CITY OF ALBUQUERQUE

November 1, 2019

Re: Louisiana Plaza
7200 Montgomery Blvd NE
Traffic Circulation Layout
Engineer's/Architect's Stamp 10-21-19 (G19D016A)

CENTER SITE PLAN
1" = 60'-0"

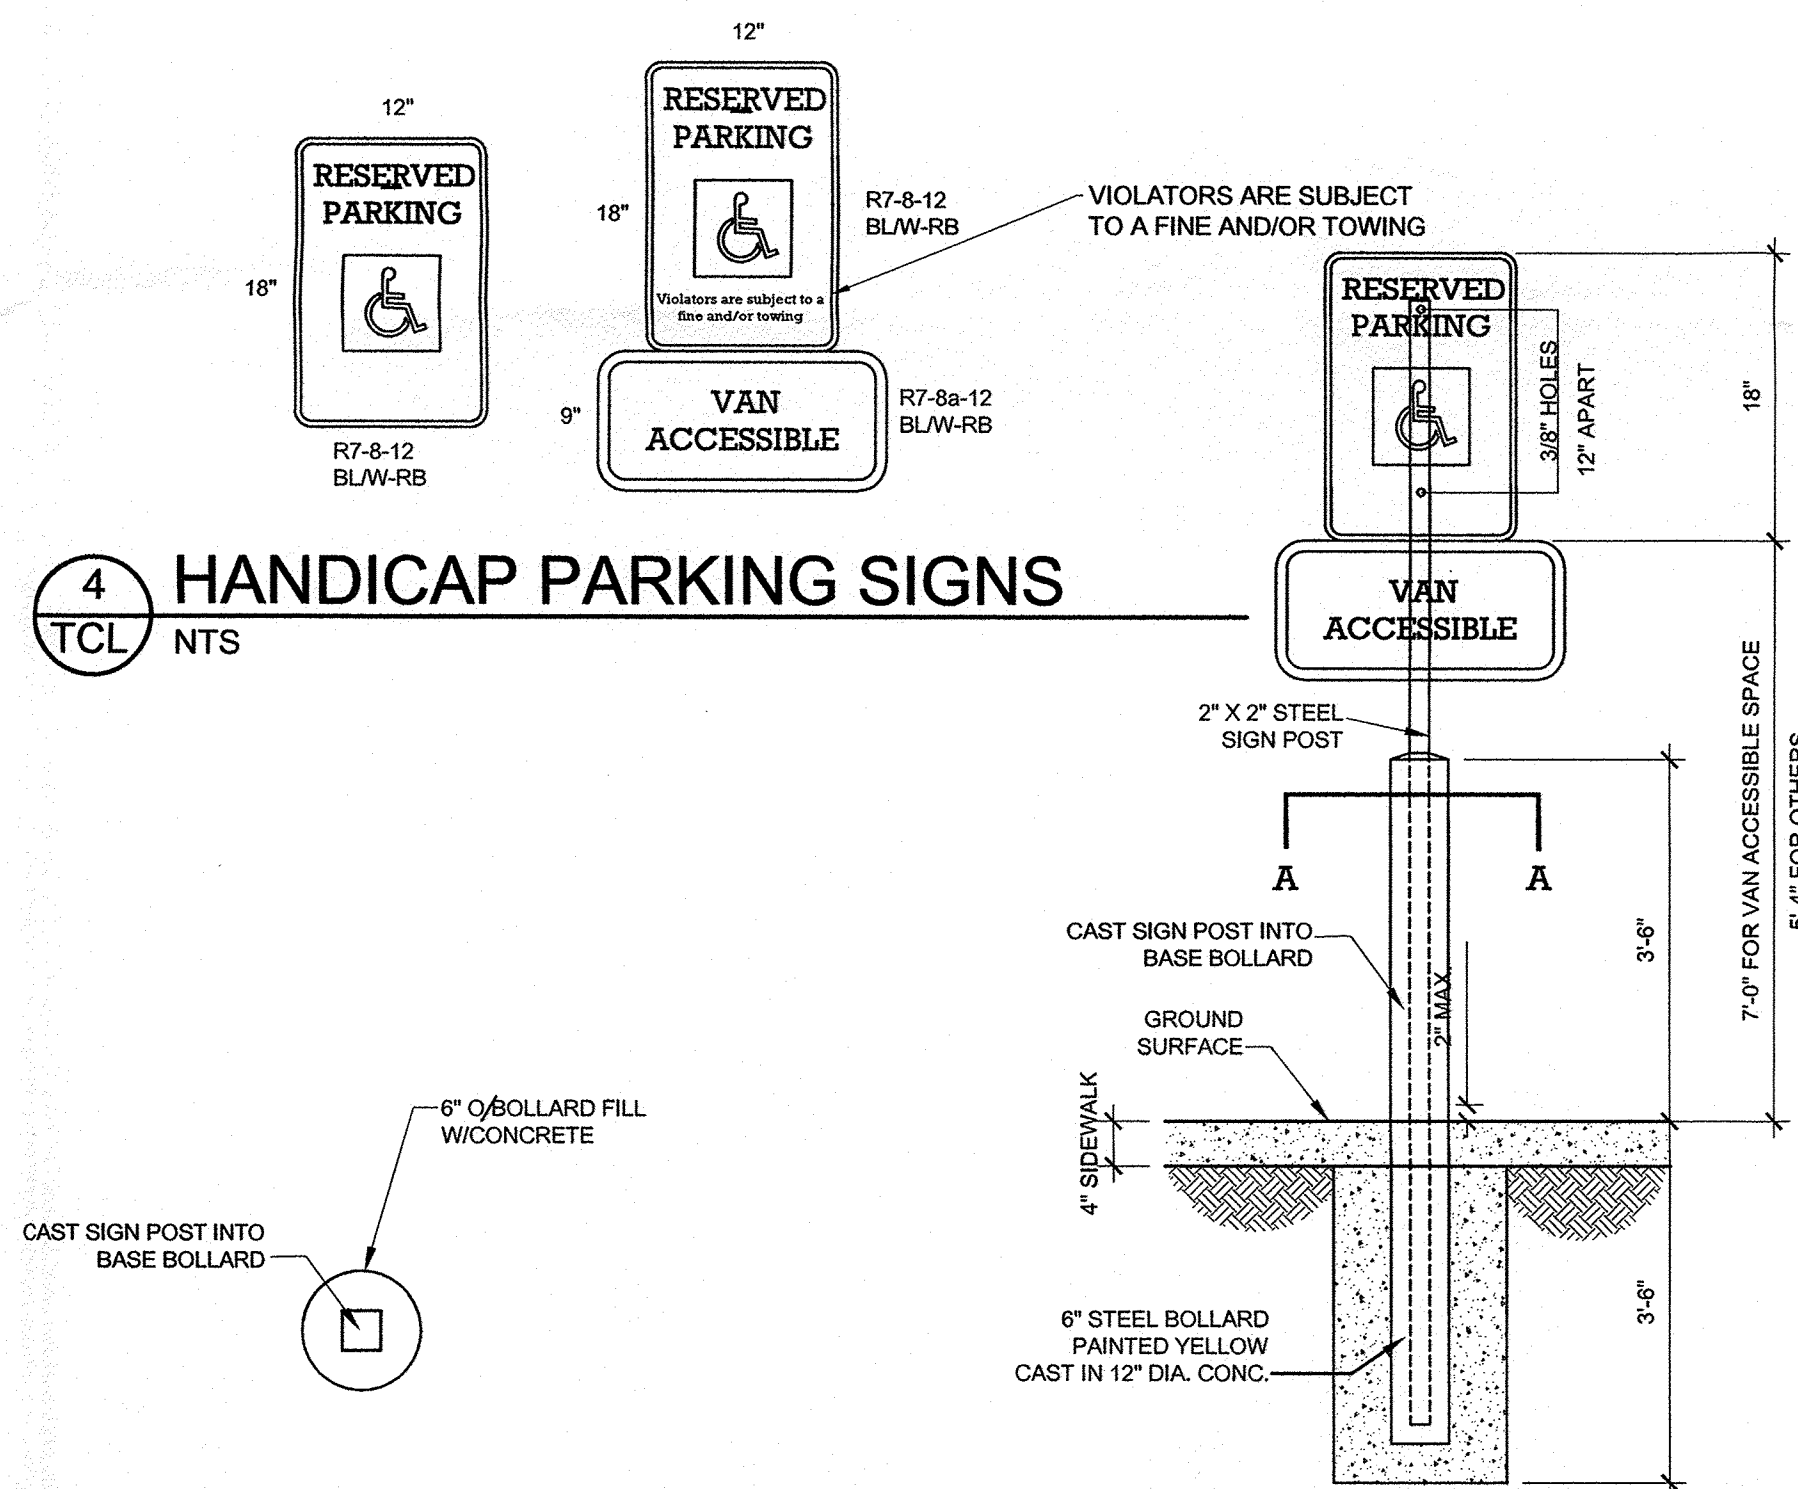
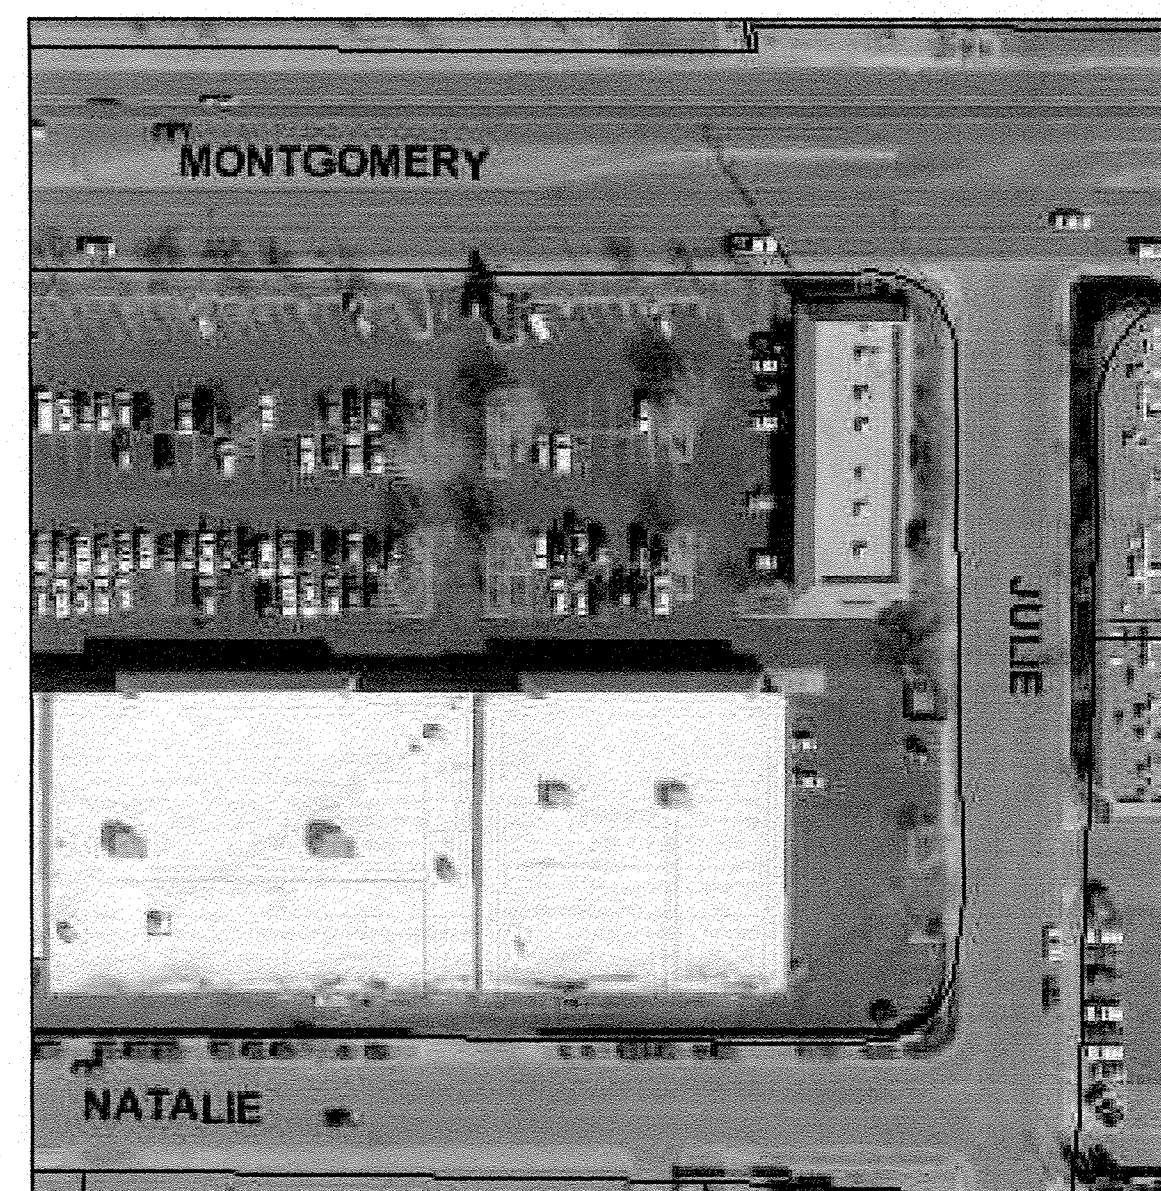
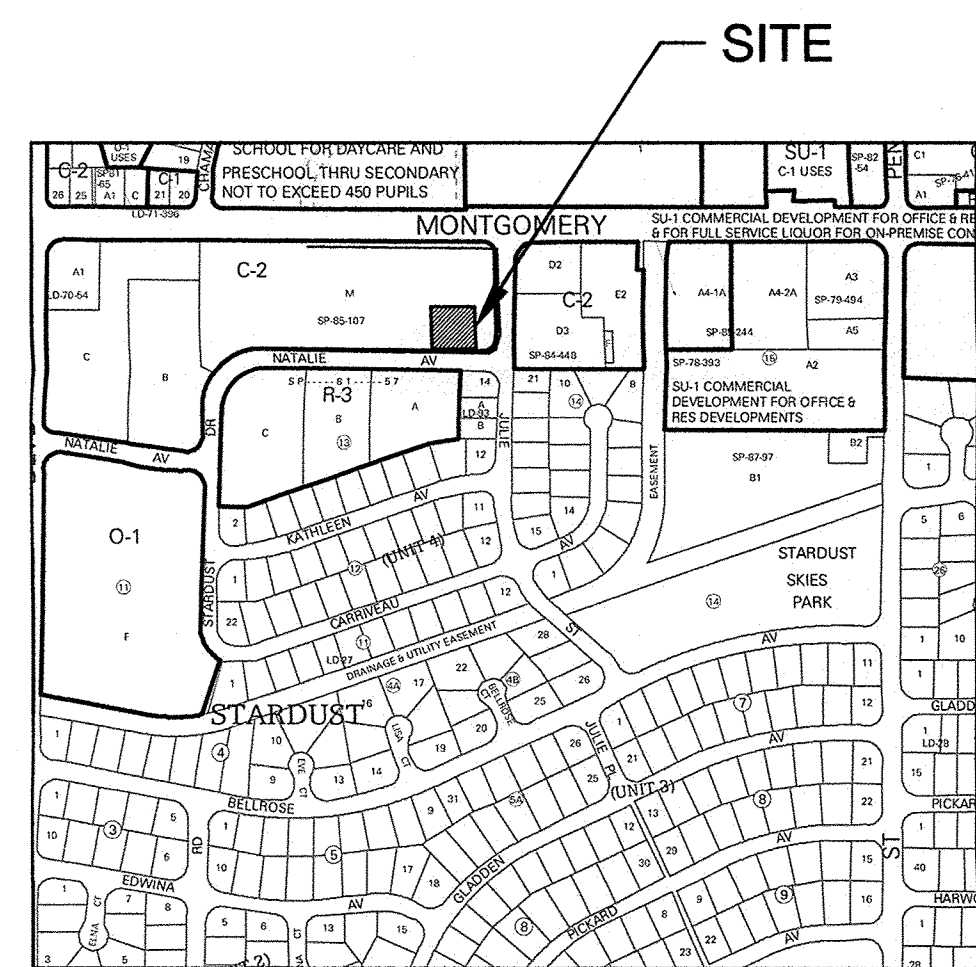
1. List the number of parking spaces required by the zoning code as well as the proposed number of parking spaces including bicycle and motorcycle parking.

2. Please list the width and length for all existing and proposed parking spaces. Some dimensions are not shown.
3. Label the compact parking spaces by placing the words "**COMPACT**" on the pavement of each space.

5. All bicycle racks shall be designed according to the following guidelines:
 - a. The rack shall be a minimum 30 inches tall and 18 inches wide.
 - b. The bicycle frame shall be supported horizontally at two or more places. Comb/toaster racks are not allowed.

- c. The rack shall be designed to support the bicycle in an upright position. See the IDO for additional information.
 - d. The rack allows varying bicycle frame sizes and styles to be attached.

- e. The user is not required to lift the bicycle onto the bicycle rack.
 - f. Each bicycle parking space is accessible without moving another bicycle.

6. Bicycle racks shall be sturdy and anchored to a concrete pad.
7. A 1-foot clear zone around the bicycle parking stall shall be provided.
8. Bicycle parking spaces shall be at least 6 feet long and 2 feet wide.

9. Per the IDO, a 6 ft. wide ADA accessible pedestrian pathway is required from the public sidewalk to the building entrances. Please clearly show this pathway and provide details.

6 SIGN MOUNTING DETAIL
TCL NTS

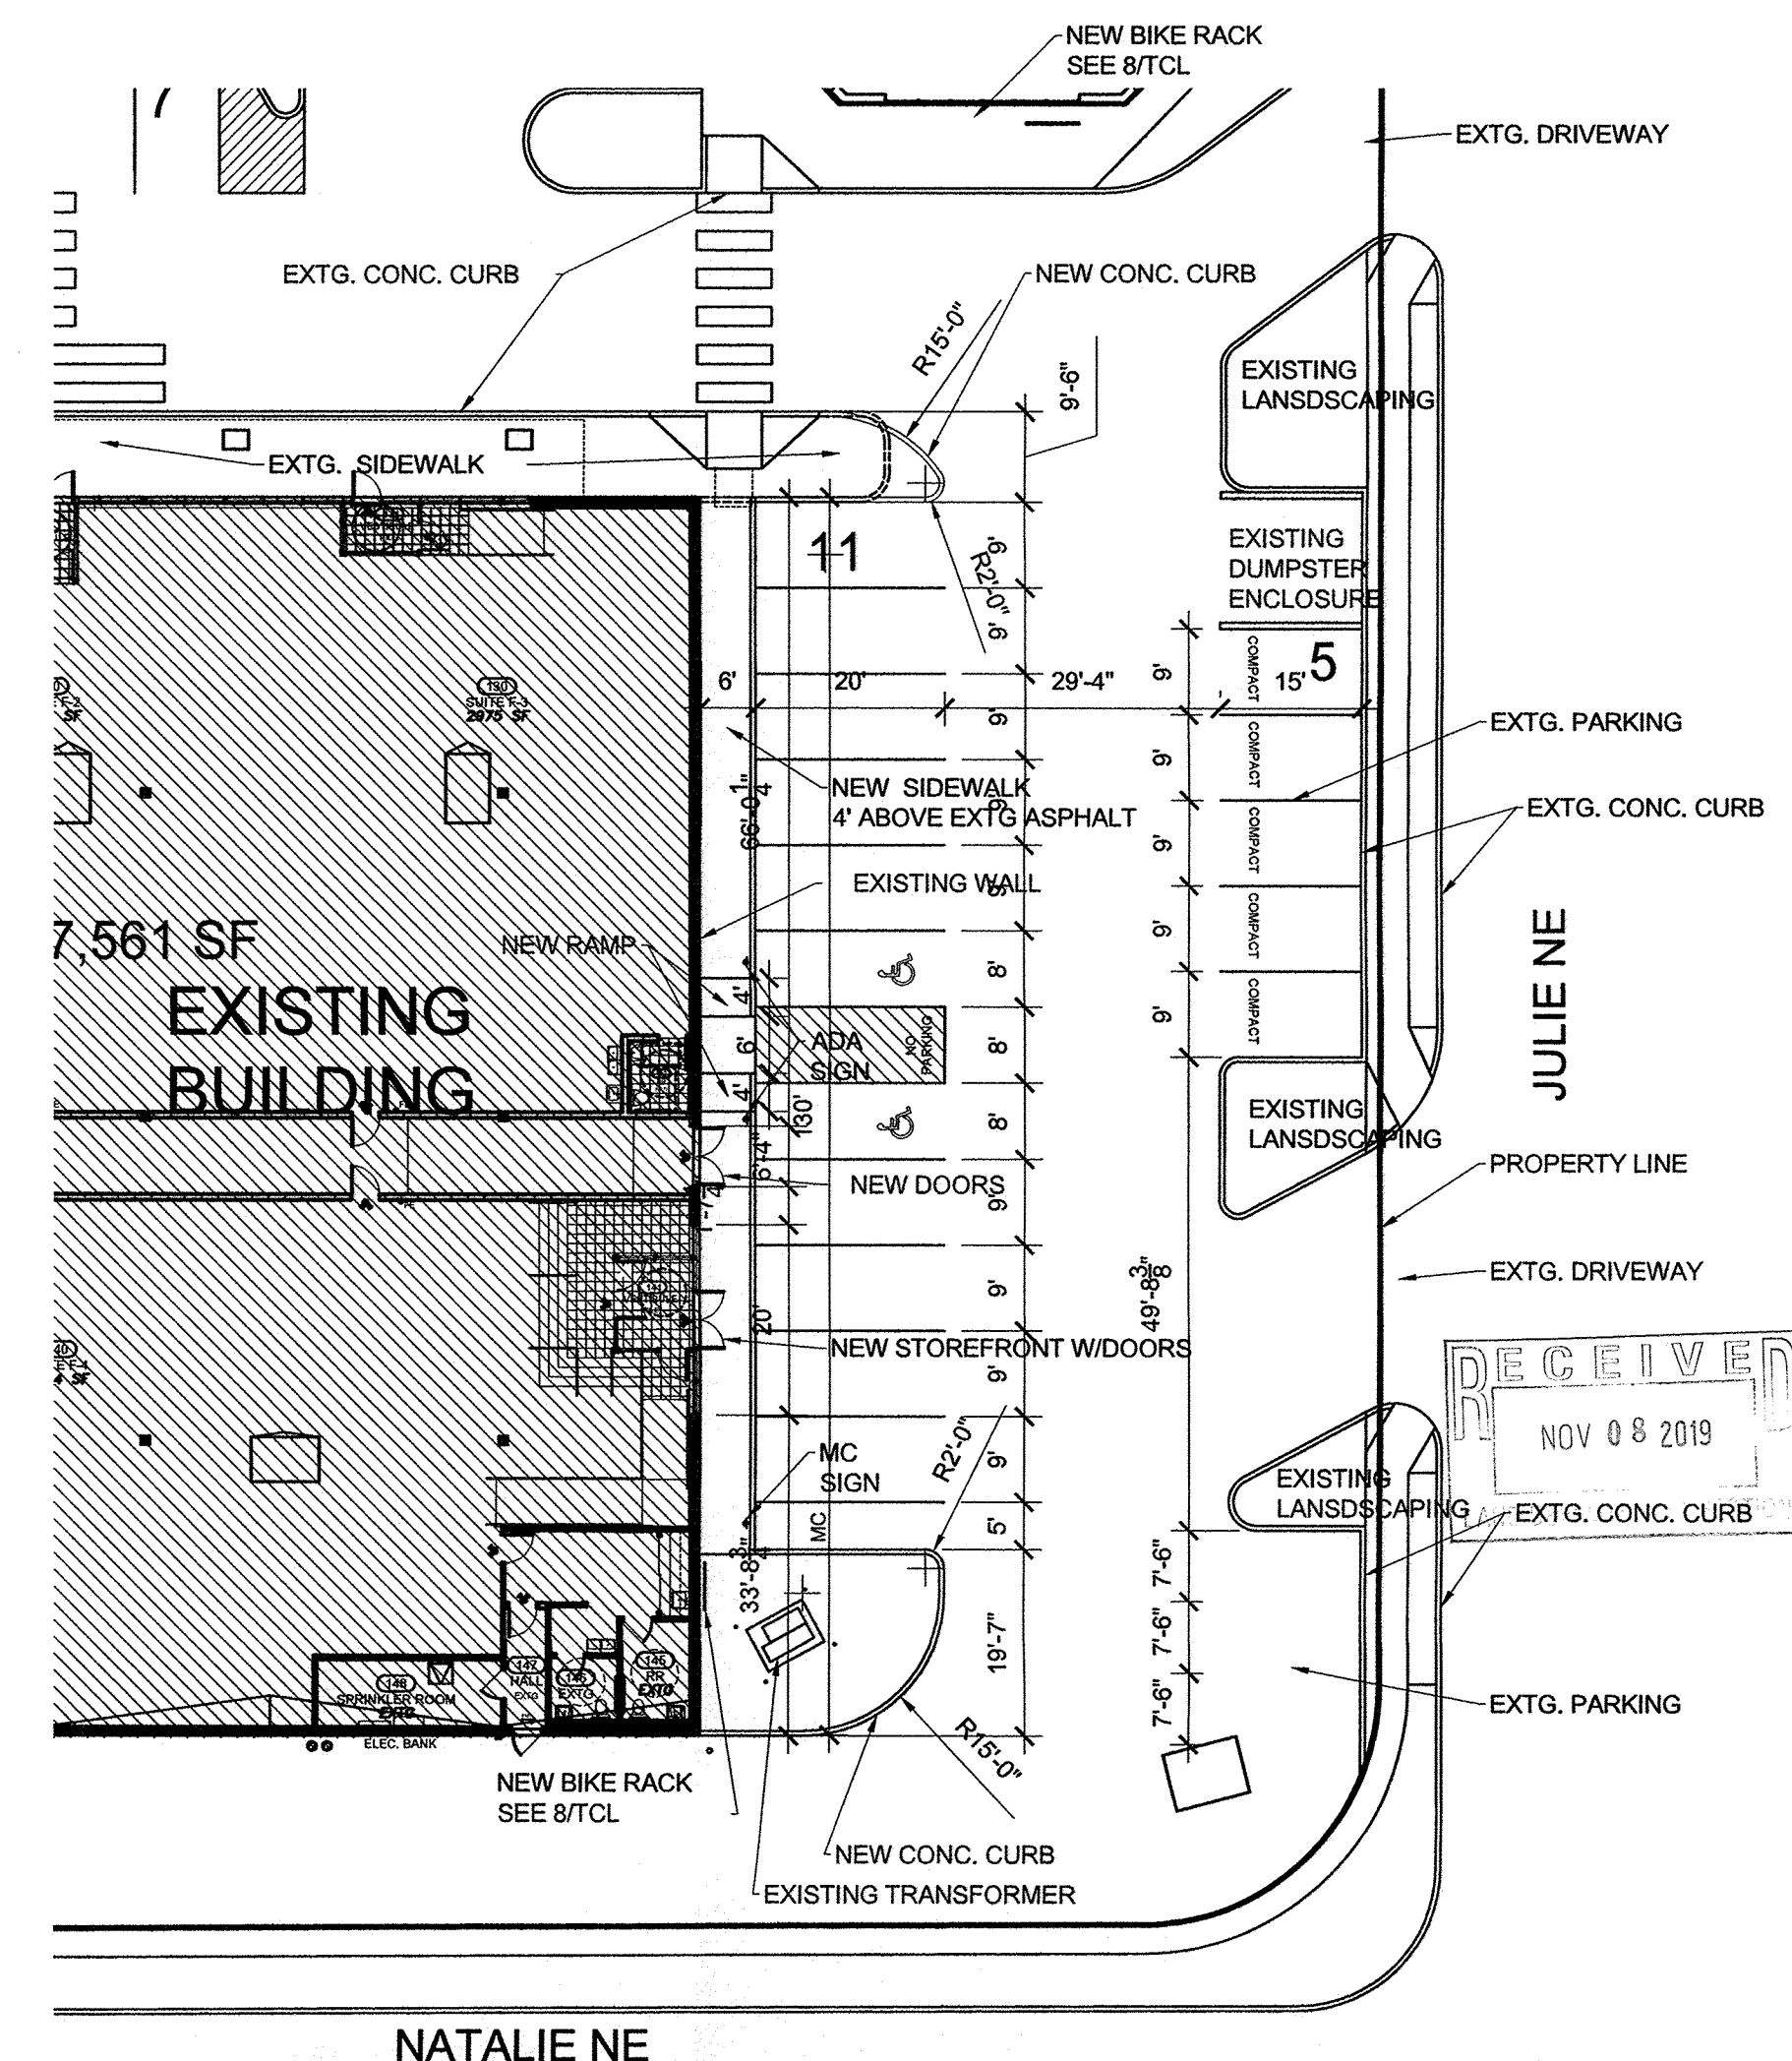
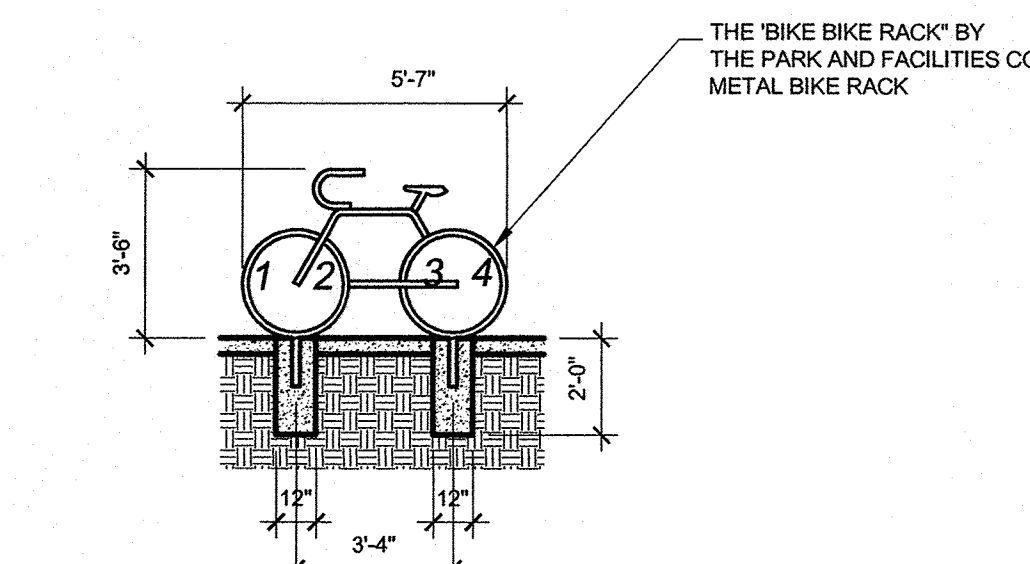
4. The ADA accessible parking sign must have the required language per 66-7-352.4C NMSA 1978 "**Violators Are Subject to a Fine and/or Towing.**" Please call out detail and location of signs.
